Planning Application Reference No.: 3/2024/0096

Address of Development: Longridge high school

Fencing Replacement Scheme at Longridge High School, Preston Road, Longridge, Lancashire, PR3 3AR

DRAWING TITLE:
Site Plan with Proposed Fencing

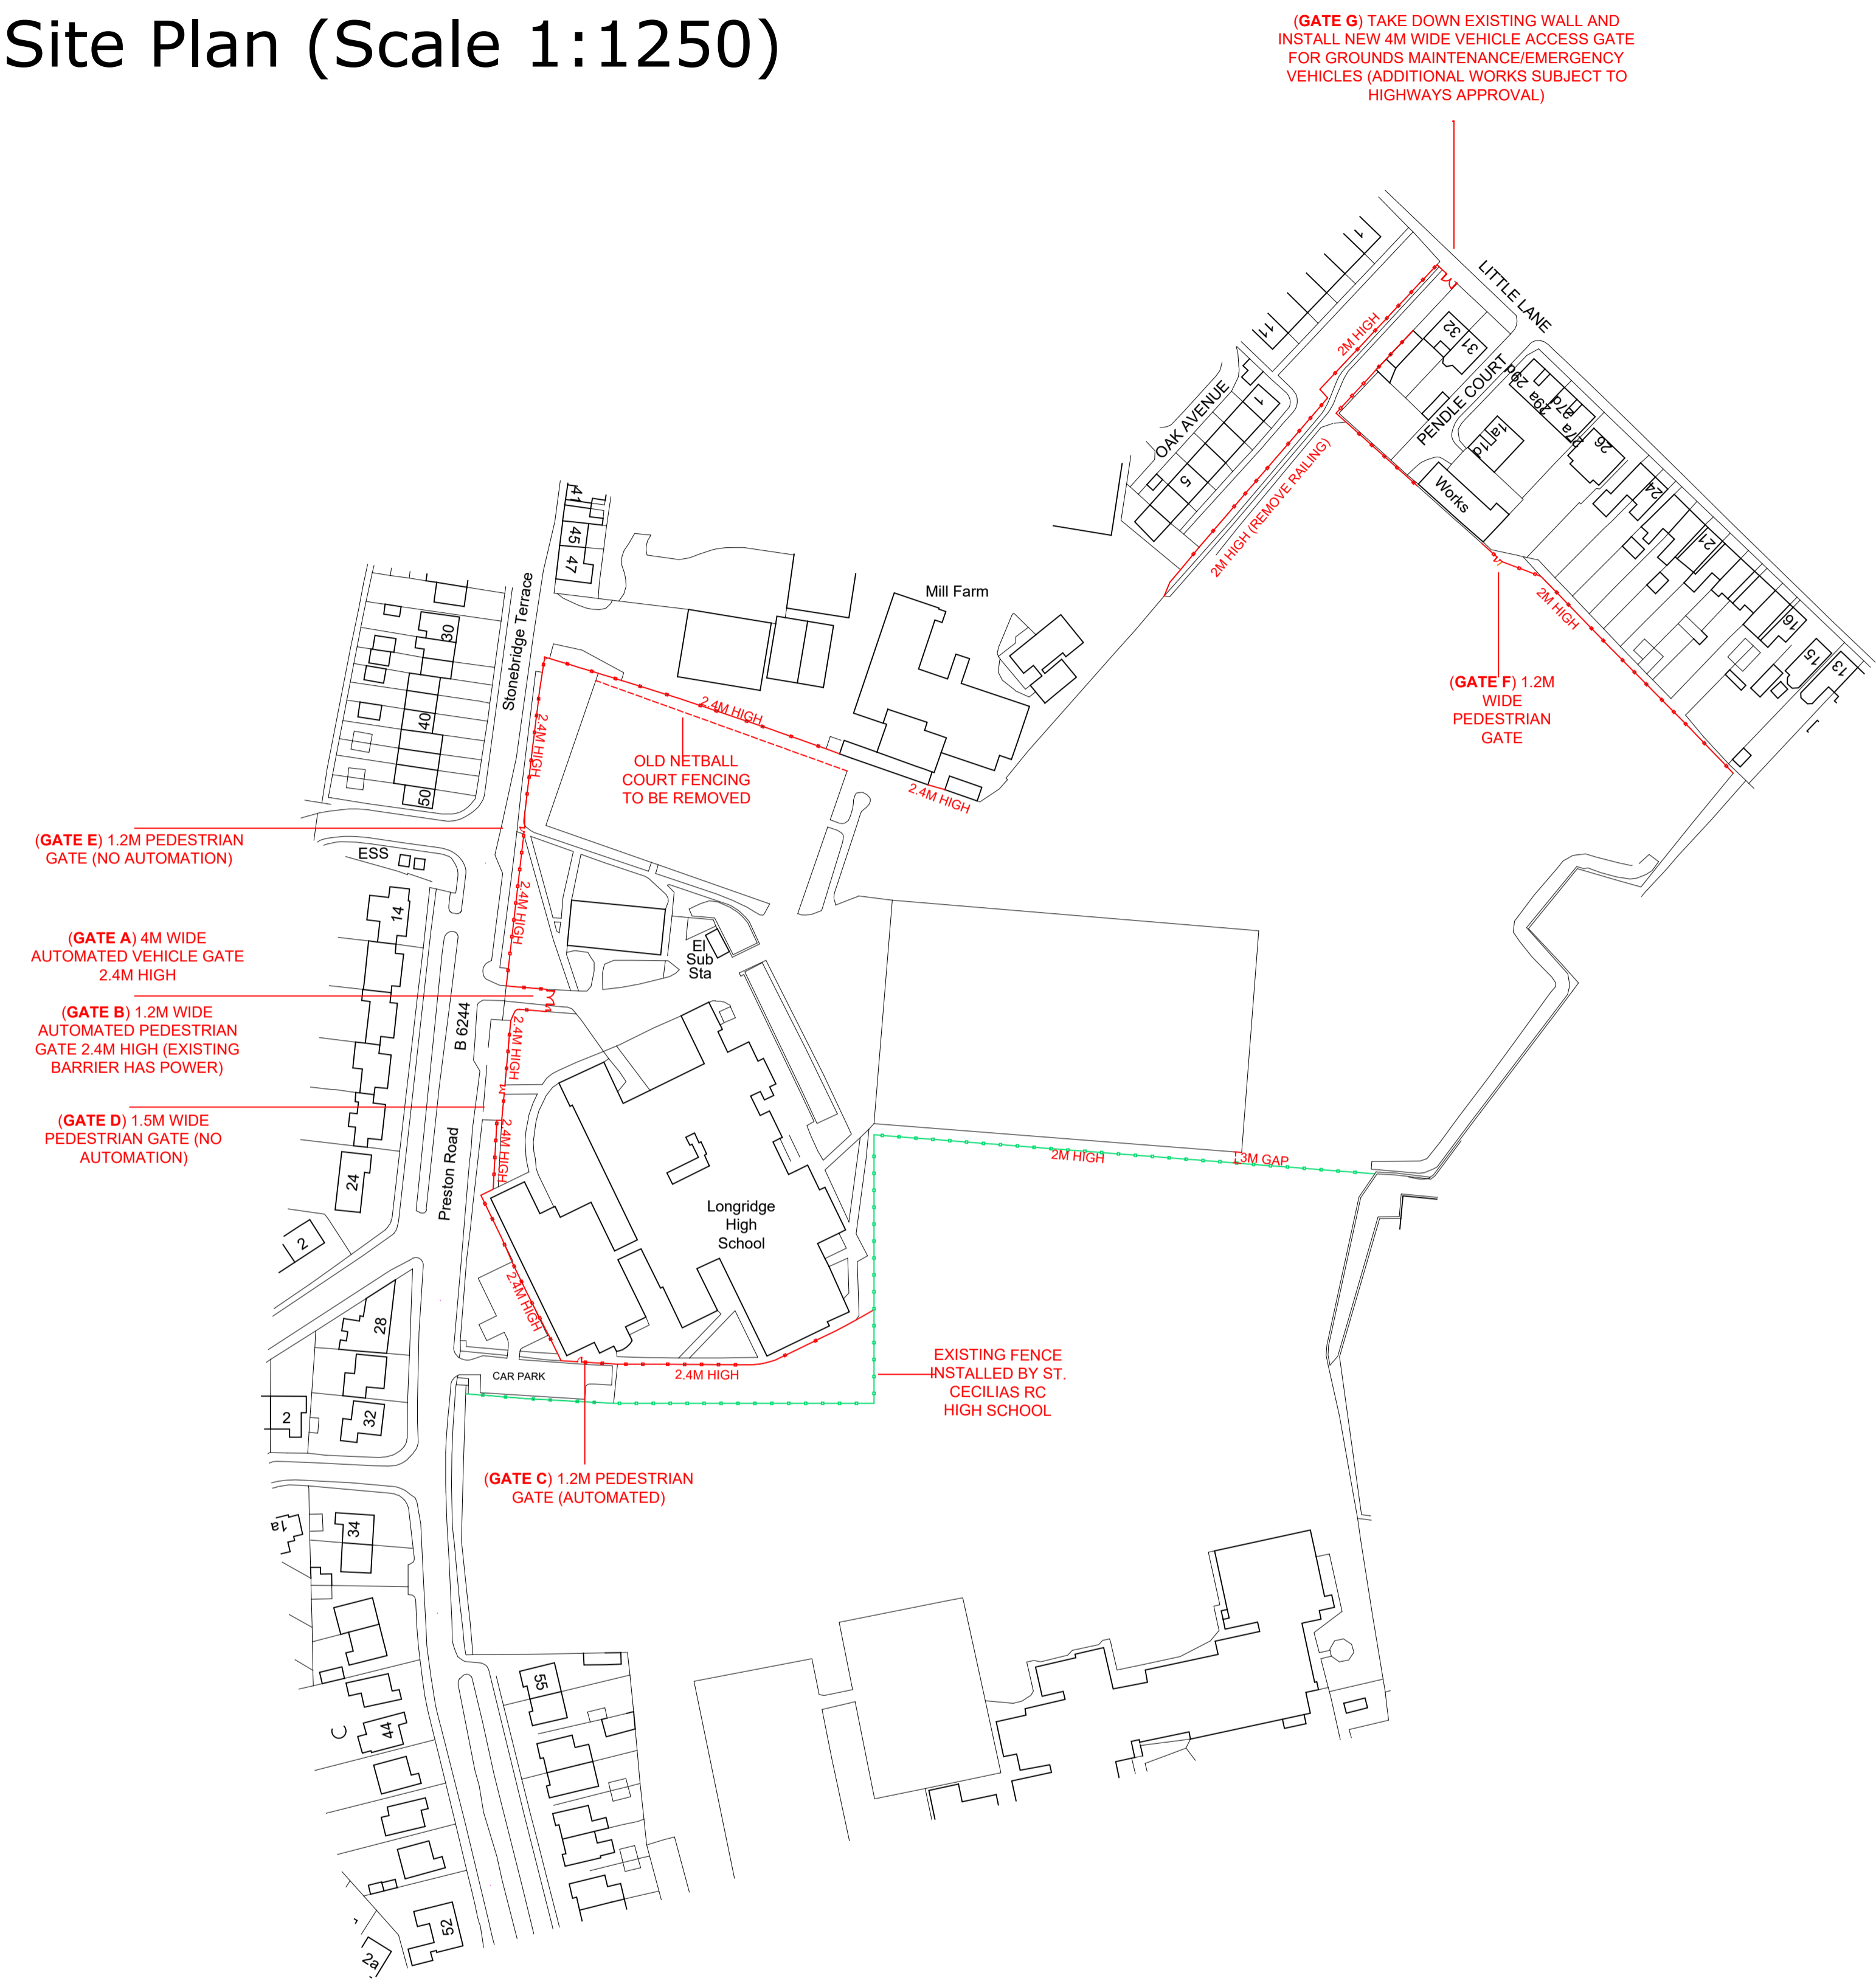
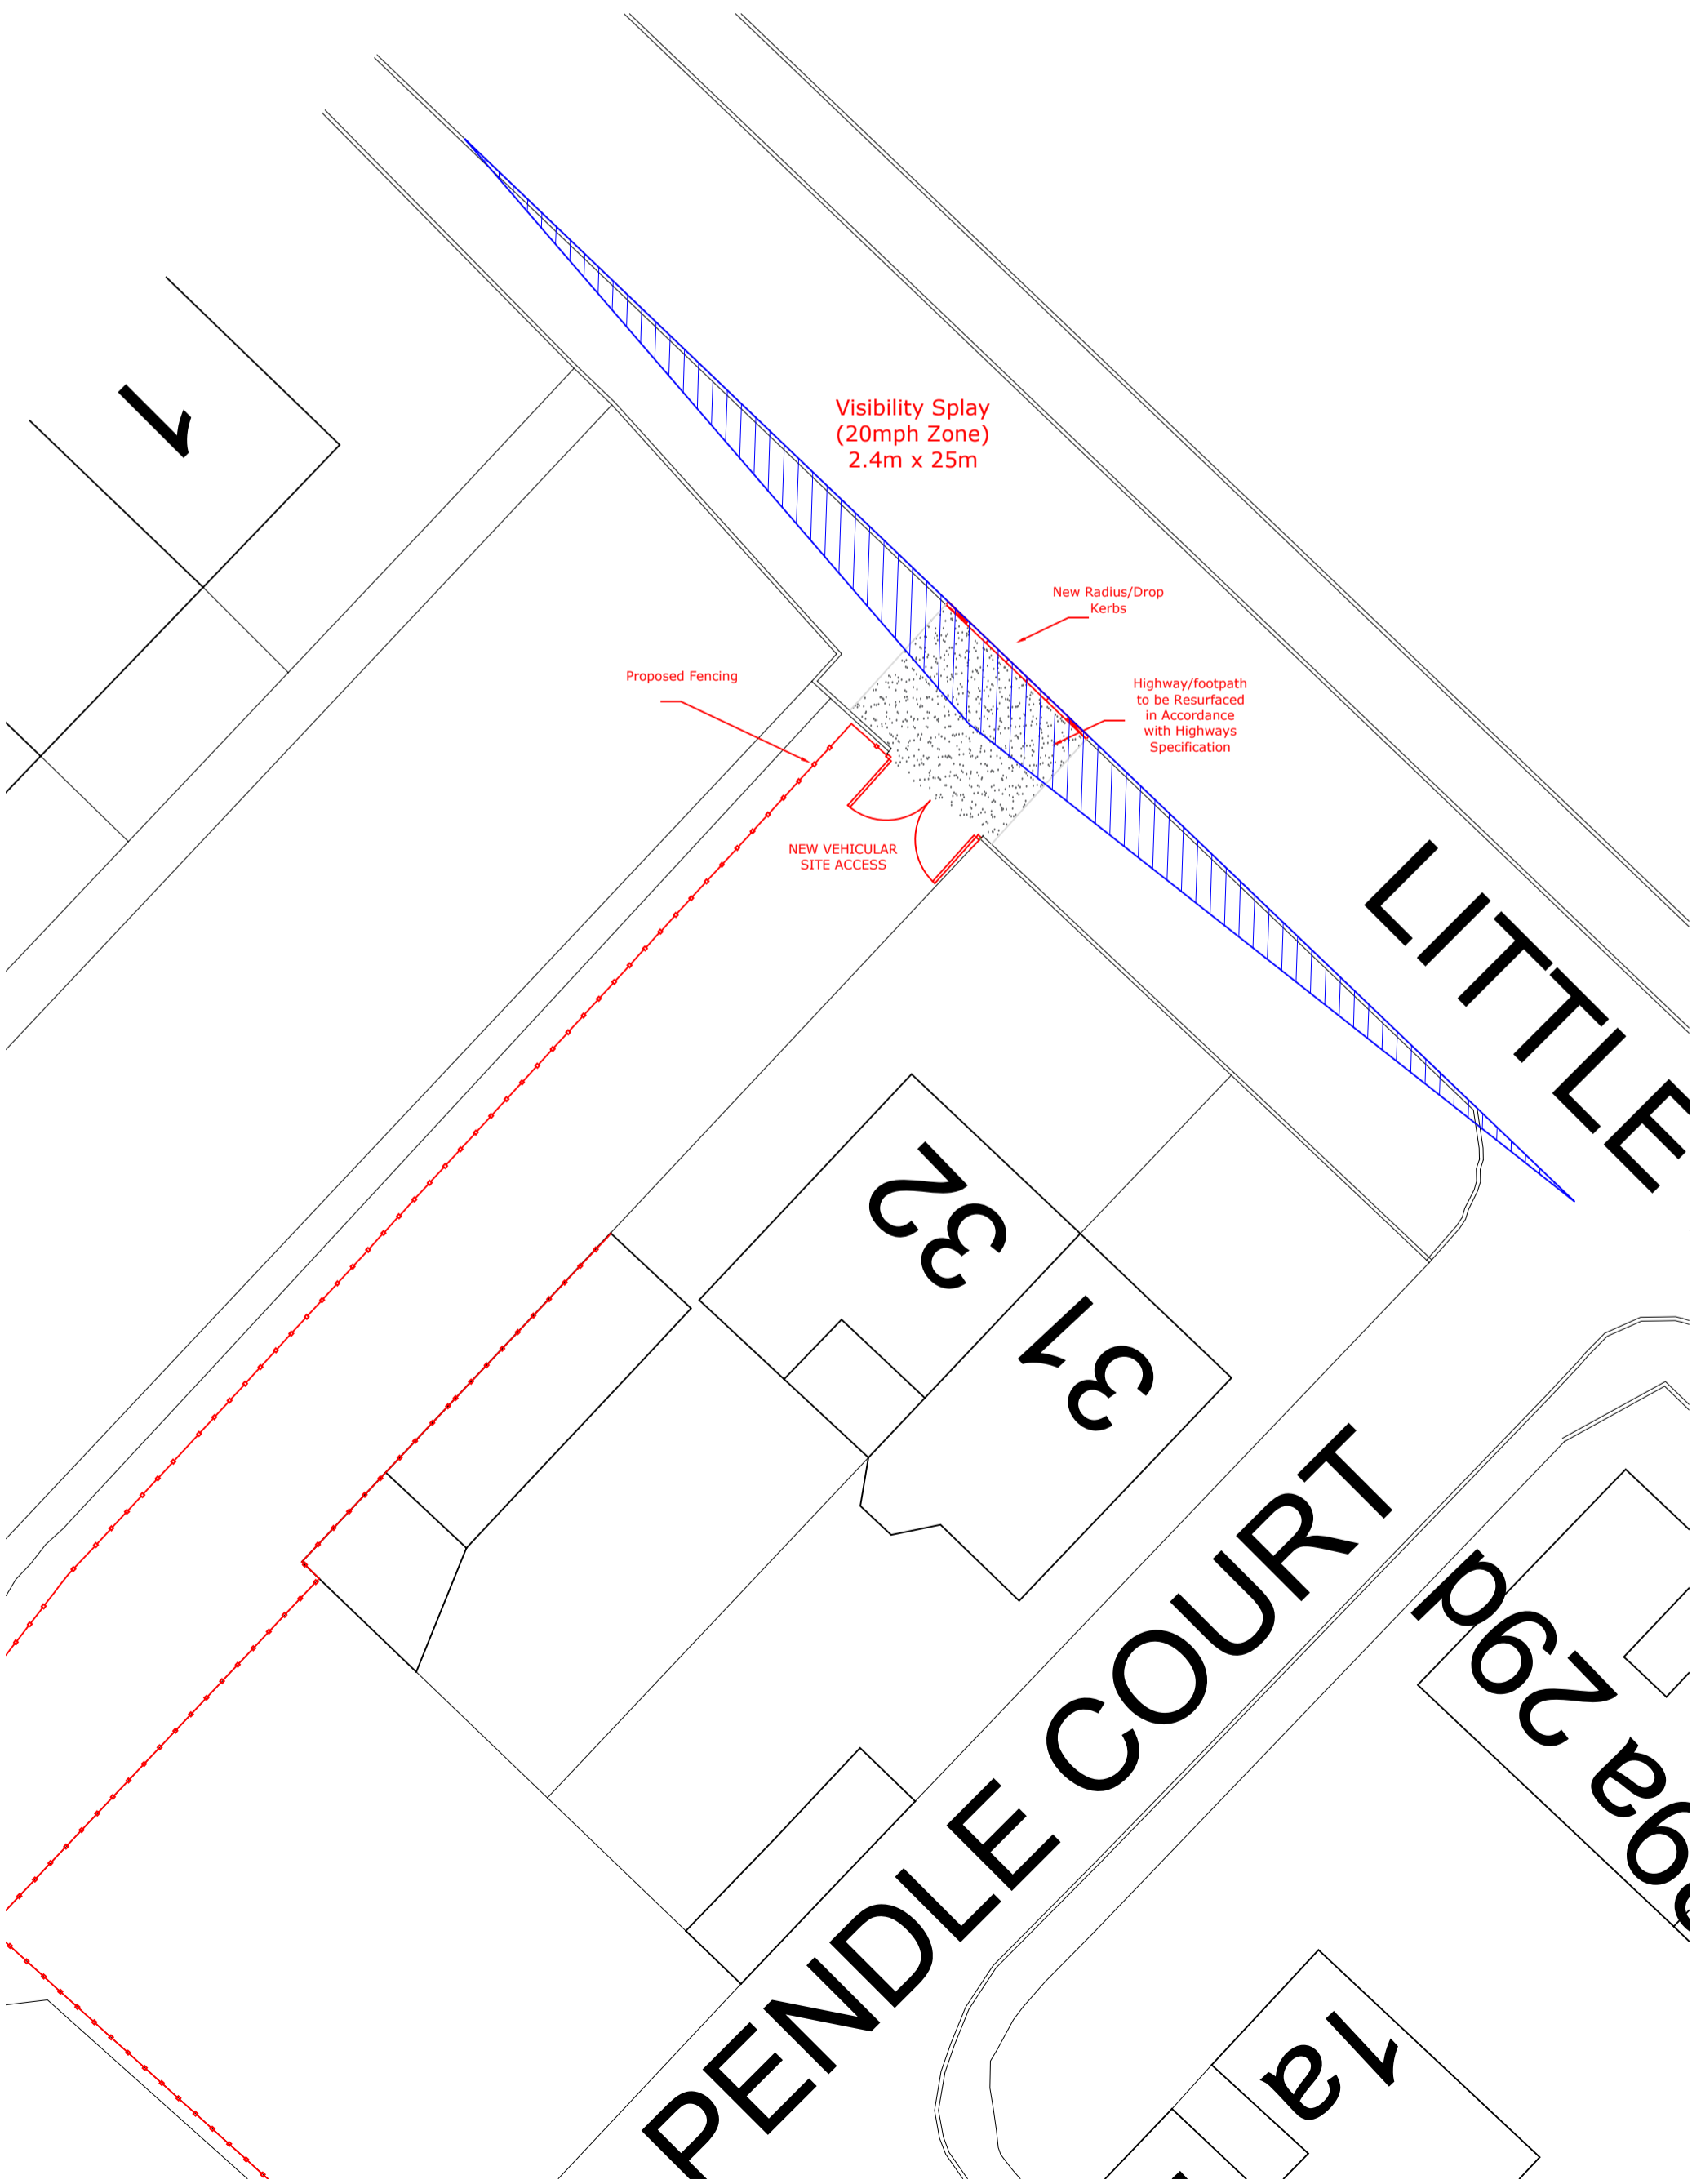
My first real objection is that it could be dangerous the gates appear to be close to the road which means that vehicles wanting to get through the gates would have to park on the narrow road blocking the road while someone gets out to open the gates gets back into the vehicle and drives down this seemingly pointless short road, the parking on the road while closing the gates also applies to leaving the site.

The new road does not appear to be wide enough for a vehicle of any size to turn around this means that when the vehicle is leaving the site it will have to reverse out onto a narrow but reasonably busy road residential road with many parked cars wich often block line of sight again a potentially dangerous situation. At certain times of the day lots of pupils from St Cecilia's school walk along Little Lane.

My suggestion to mitigate some of the issues would be to have gates several yards further back from the road so that any vehicles can turn into the site and while the vehicle is then off the road the gates if required can then be opened and the vehicle can move through again when leaving the site the vehicle can reverse out shut the gates before reversing onto the road. However this would <u>not</u> address my main safety concern about vehicles reversing onto the road.

The better option would be to have access via the existing road Pendle Court only 20 metres away.

I question the need for a two metre high fence and gate when it is surrounding a fairly low use sports field away from the main school complex. We feel the high gate and fence will be visually obtrusive make it look like at best an industrial area and at worst a prison camp. This applies to us and all the surrounding houses. We would question why something that is a detriment to the surrounding properties removing views over a green space needs to be constructed for no obvious reason.

The playing field is surrounded by very steep slopes a fence at the bottom of the slope would be far less obtrusive and would have little or no impact on the useable space of the playing field.

We note the use of the word 'Typical'. The term is non-specific. We see a 'Typical' specification of 2 (two) metres, when a measurement of 2.4 metres is mentioned in the Design and Access Statement. We feel we are in process of being misled!

What height of fence is it proposed be erected outside our homes?

The plan carries no Key to the use of colour in the lines on the drawing. Are we meant to guess?
